Consultation Response from KC, Conservation and Design
2021/92462 rear of, 1091, Manchester Road, Linthwaite, Huddersfield, HD7 5LS
Outline application for erection of detached dwelling
Date Responded: 21/09/21
Responding Officer: Craig McHugh
Responding Ref: CV 5/240

STATUS			PROVISIONAL		
PROJECT			LAND OFF 1091 MANCHESTER ROAD		
TITLE			PROPOSED		
CLIENT			P.WHITING		
DRAWN BY	CHECKED BY	DATE			
Author	Checker	12.05.2021			
SCALE (@ A1)		PROJECT NUMBER			
As indicated		HD.20.33			
DRAWING NUMBER				REV	
HD.20.33.01

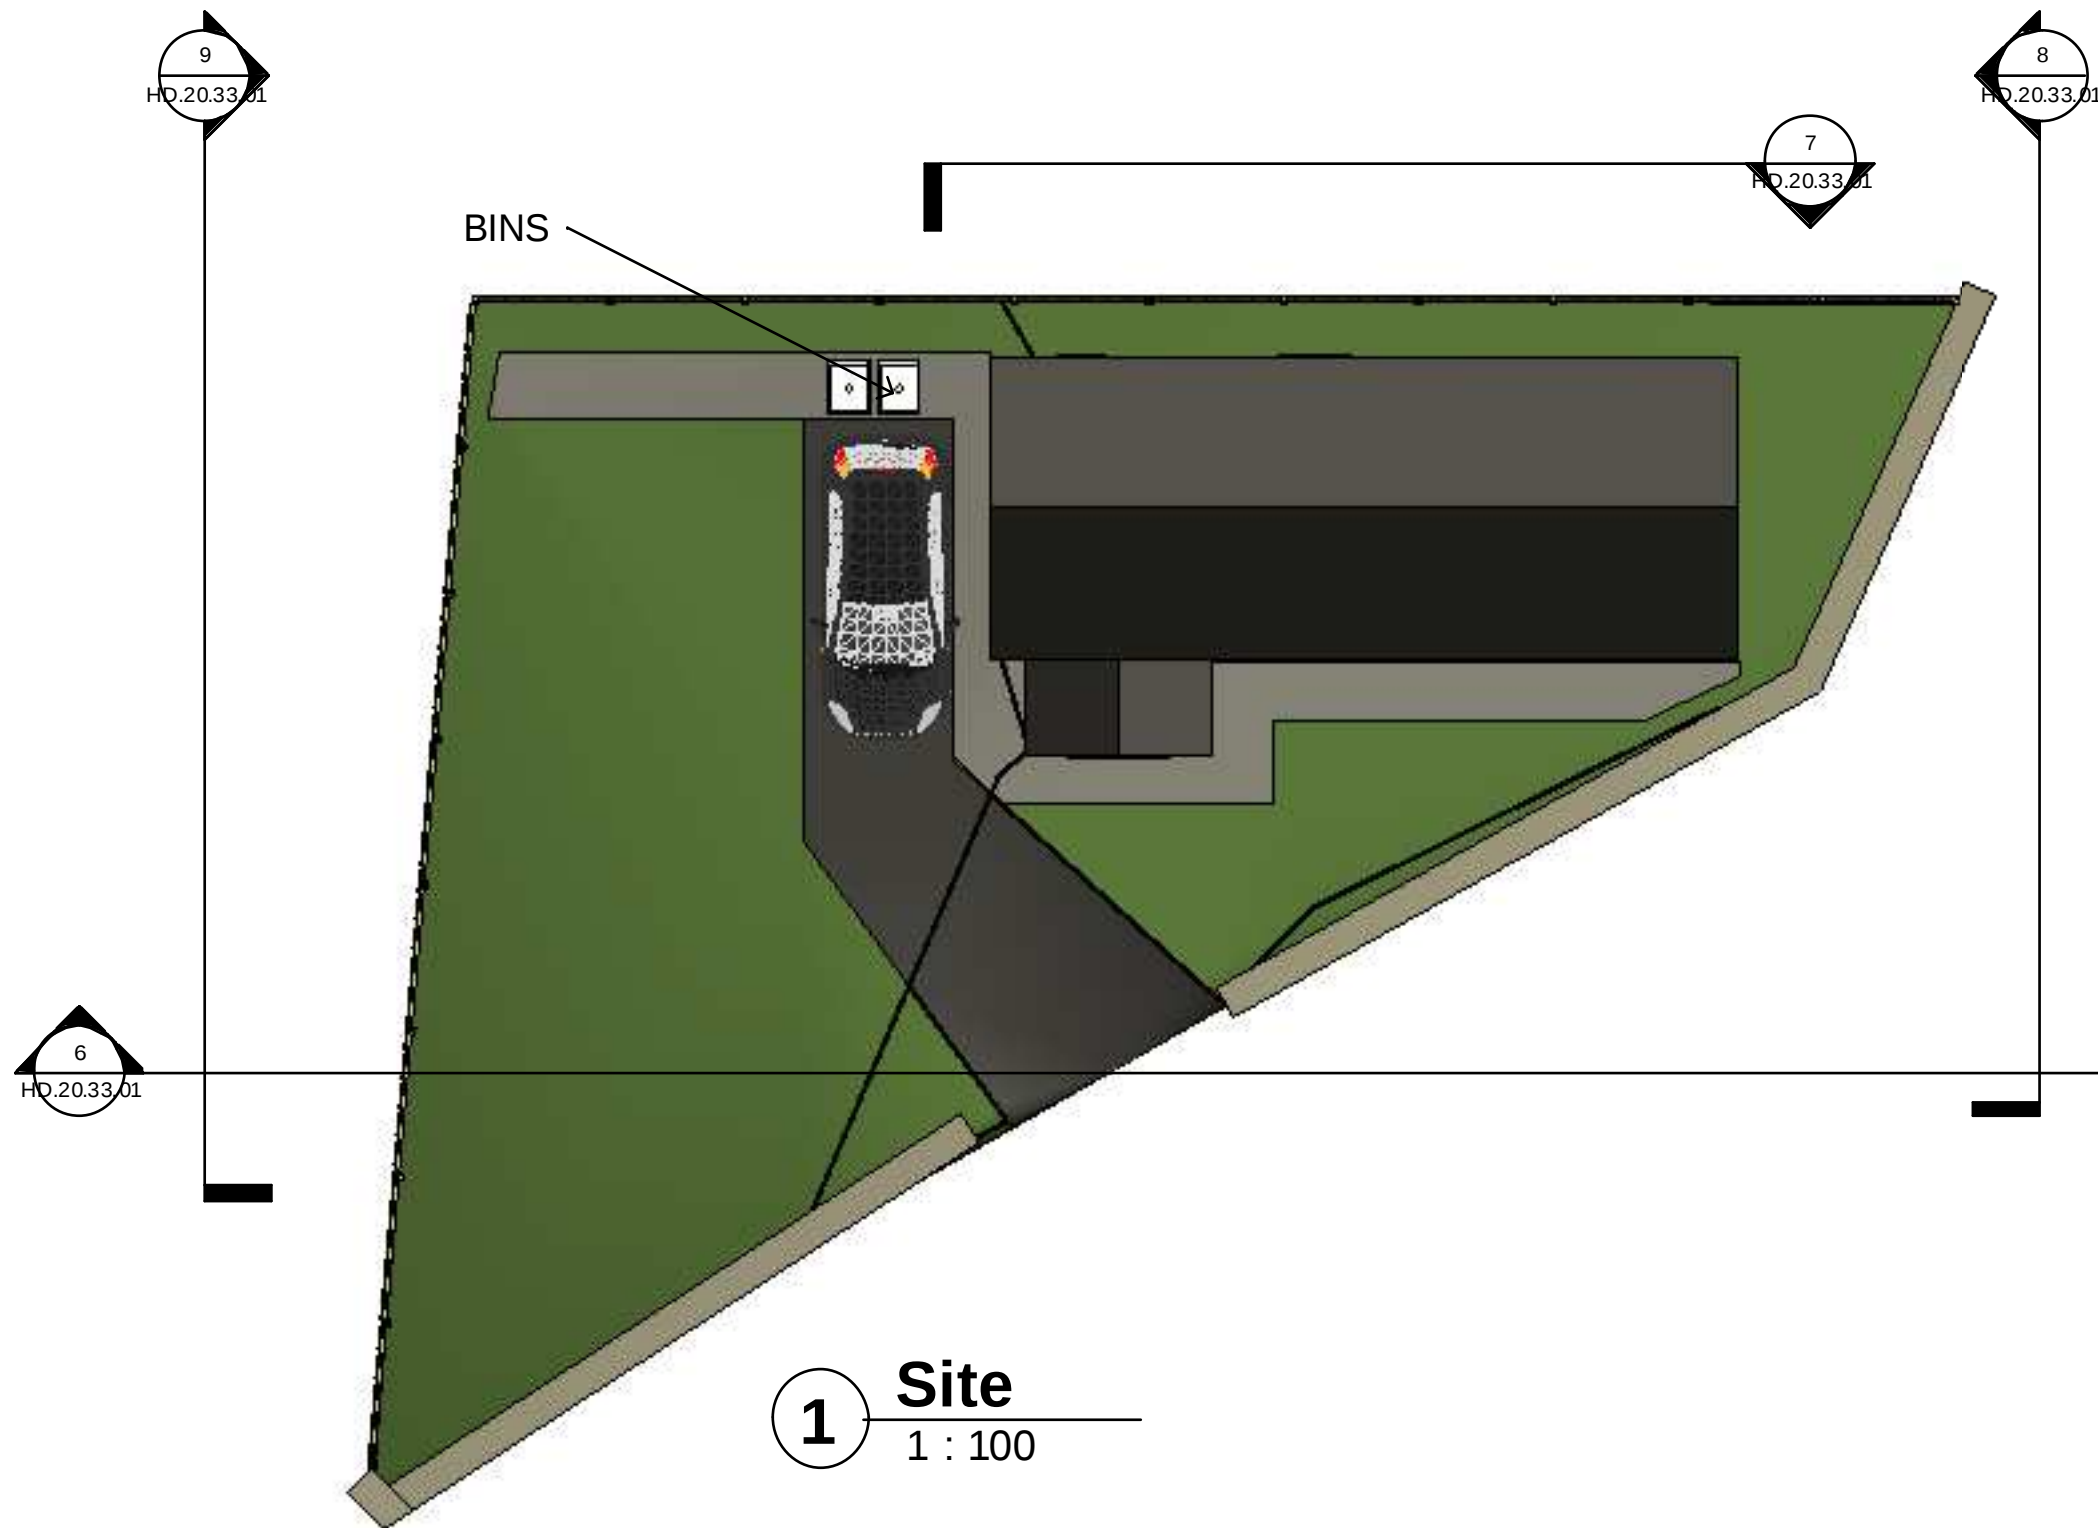
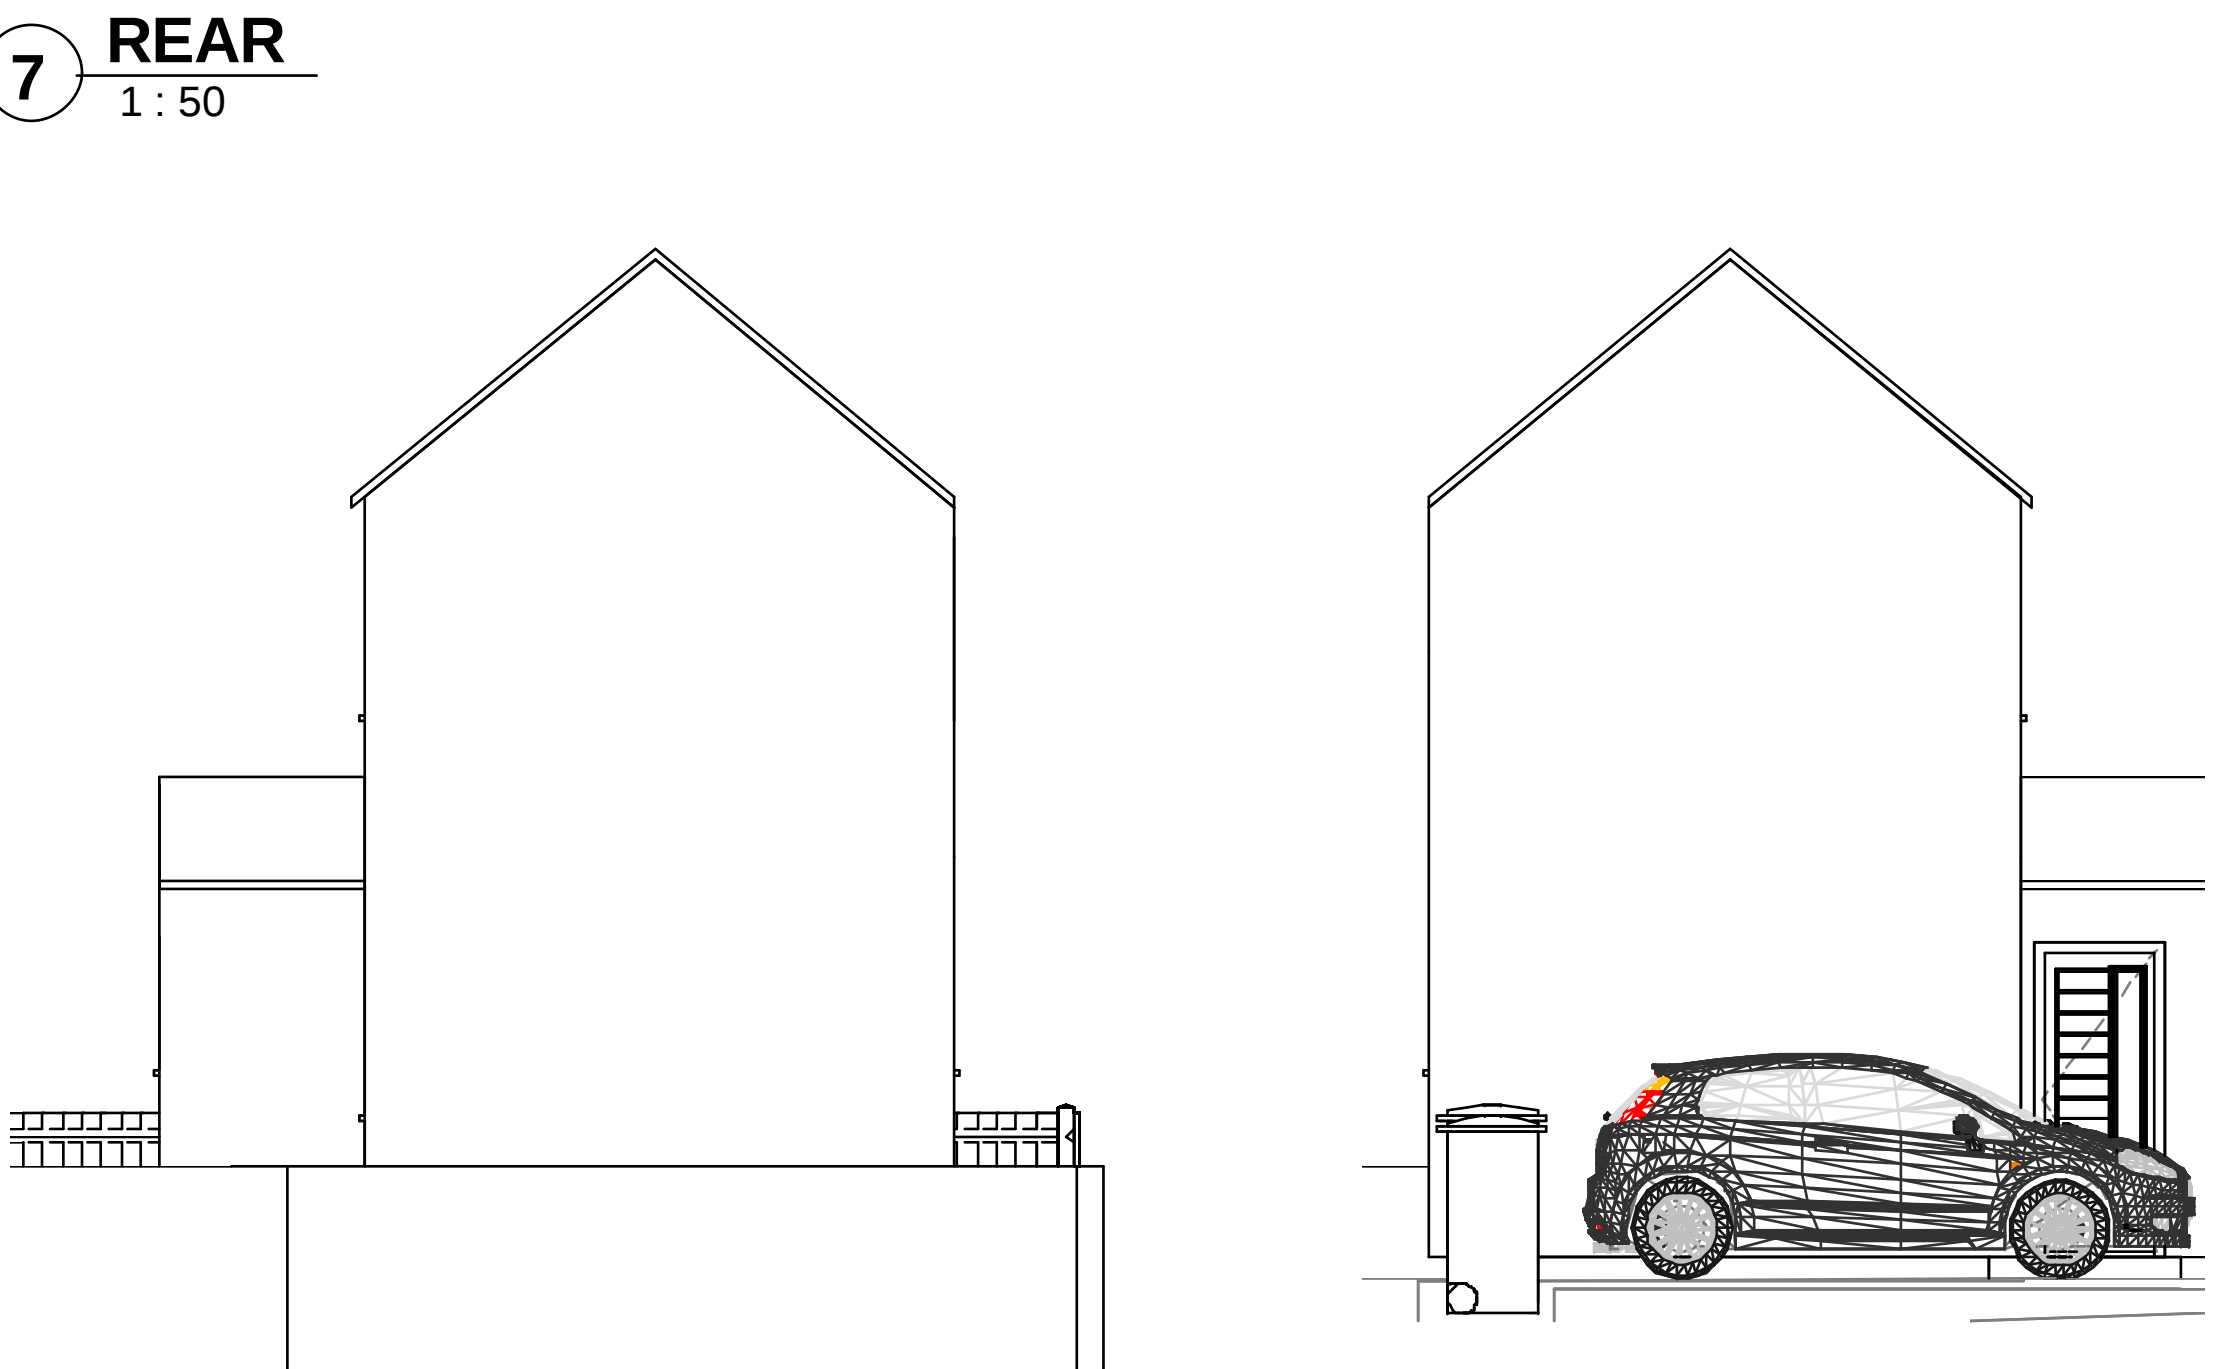
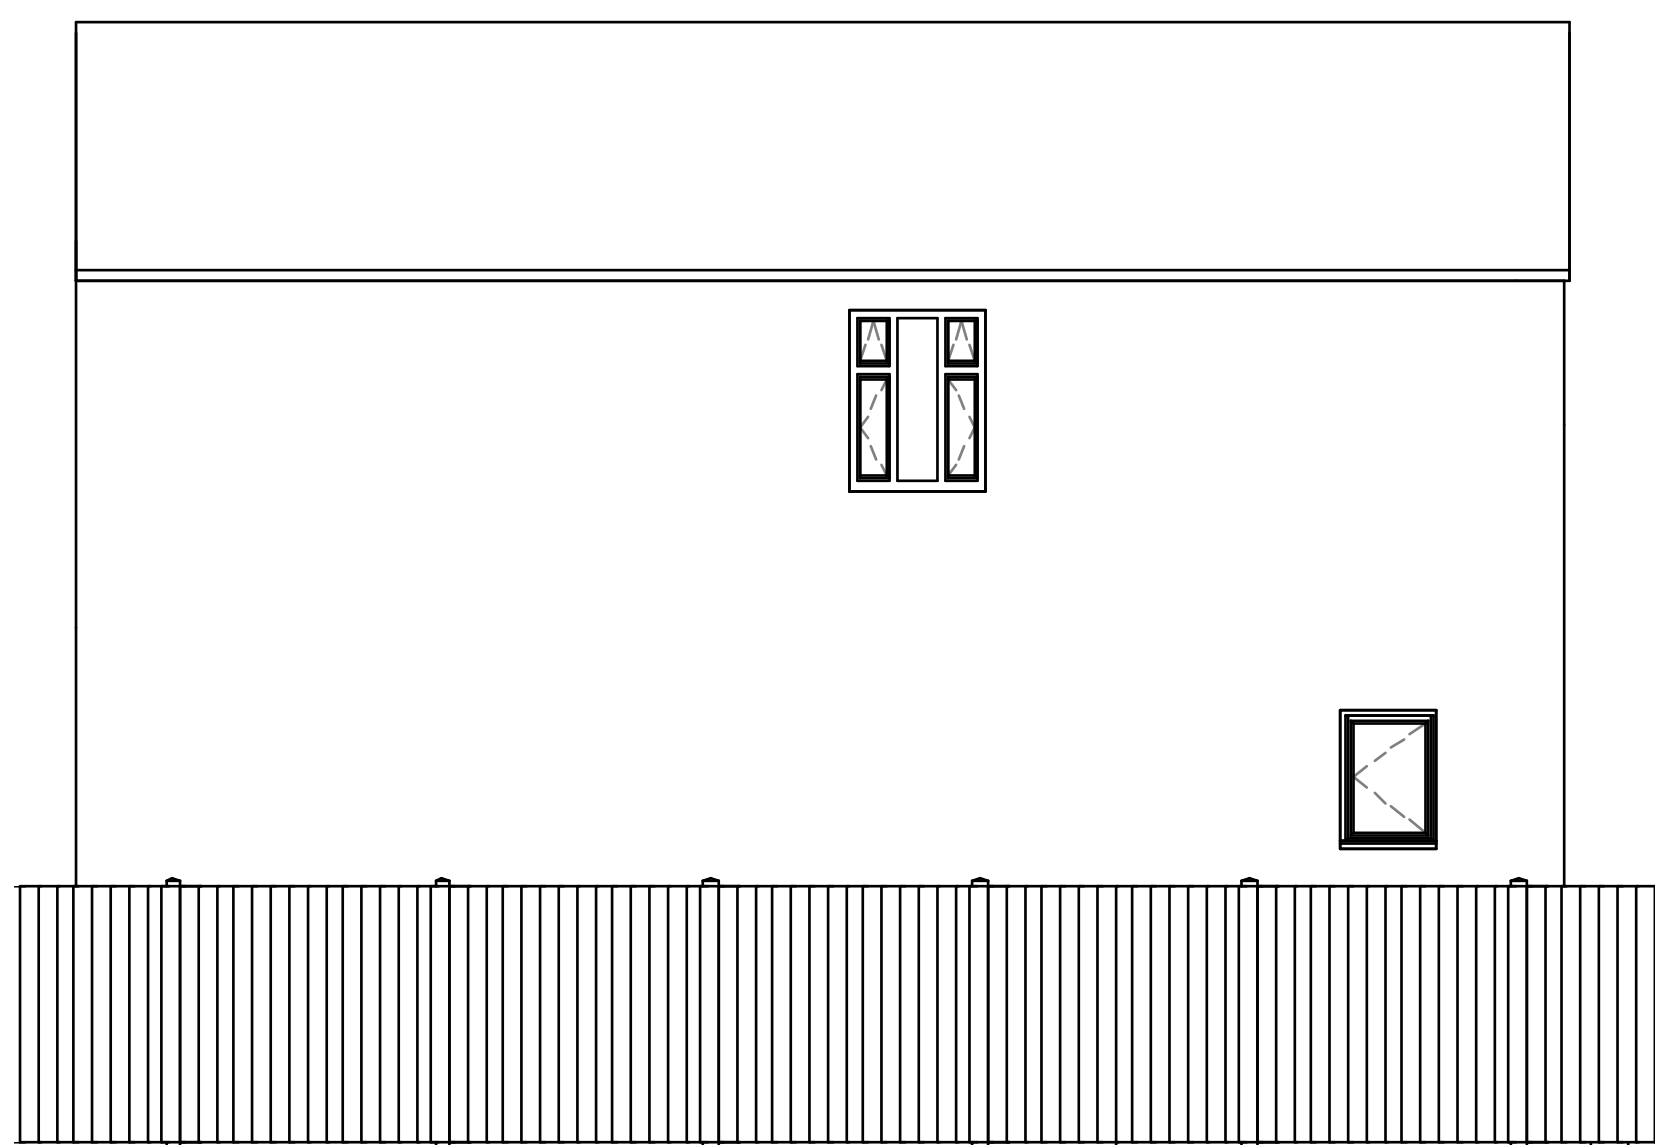
The pattern of development in Linfit Fold is dense but the application site provides an important area of open space contrasting with the built form and creating space across which to view the listed buildings, particularly those to the north. It also has an important role in views down Linfit Road from Linthwaite Hall. Development as proposed would impact on the visual relationship between the Hall and the listed buildings to the north. This area of land has historically remained undeveloped, except for small outbuildings. It therefore has an important role in the setting of the listed buildings, particularly ,3 LINFIT FOLD,1091,1093 MANCHESTER ROAD, 5 LINFIT FOLD,1089 MANCHESTER ROAD and 23,25,27,27A,29 LINTHWAITE HALL, LINFIT FOLD.

Development of the land for housing would cause a high level of harm to the setting of the adjacent listed buildings to the north and a moderate level of harm to the setting of Linthwaite Hall, this would still be less than substantial harm. Any harm is failure in principle since both the Local Plan and the NPPF set out to preserve, protect or enhance heritage assets. It would be contrary to our statutory duties under Section 66(1) and Policy LP35 of the Local Plan. It would also harm the character of the local townscape, contrary to Policy LP24.

Conservation and Design object to the proposed development on heritage grounds. The principle of development of the land for housing would cause a high level of harm to the setting of the adjacent listed buildings to the north and a moderate level of harm to the setting of Linthwaite Hall, this would still be less than substantial harm. Any harm is failure in principle since both the Local Plan and the NPPF set out to preserve, protect or enhance heritage assets. It would be contrary to our statutory duties under Section 66(1) and Policy LP35 of the Local Plan. It would also harm the character of the local townscape, contrary to Policy LP24. The harm has not been justified and the public benefits would be slight.

The application should be refused or withdrawn by the applicant.
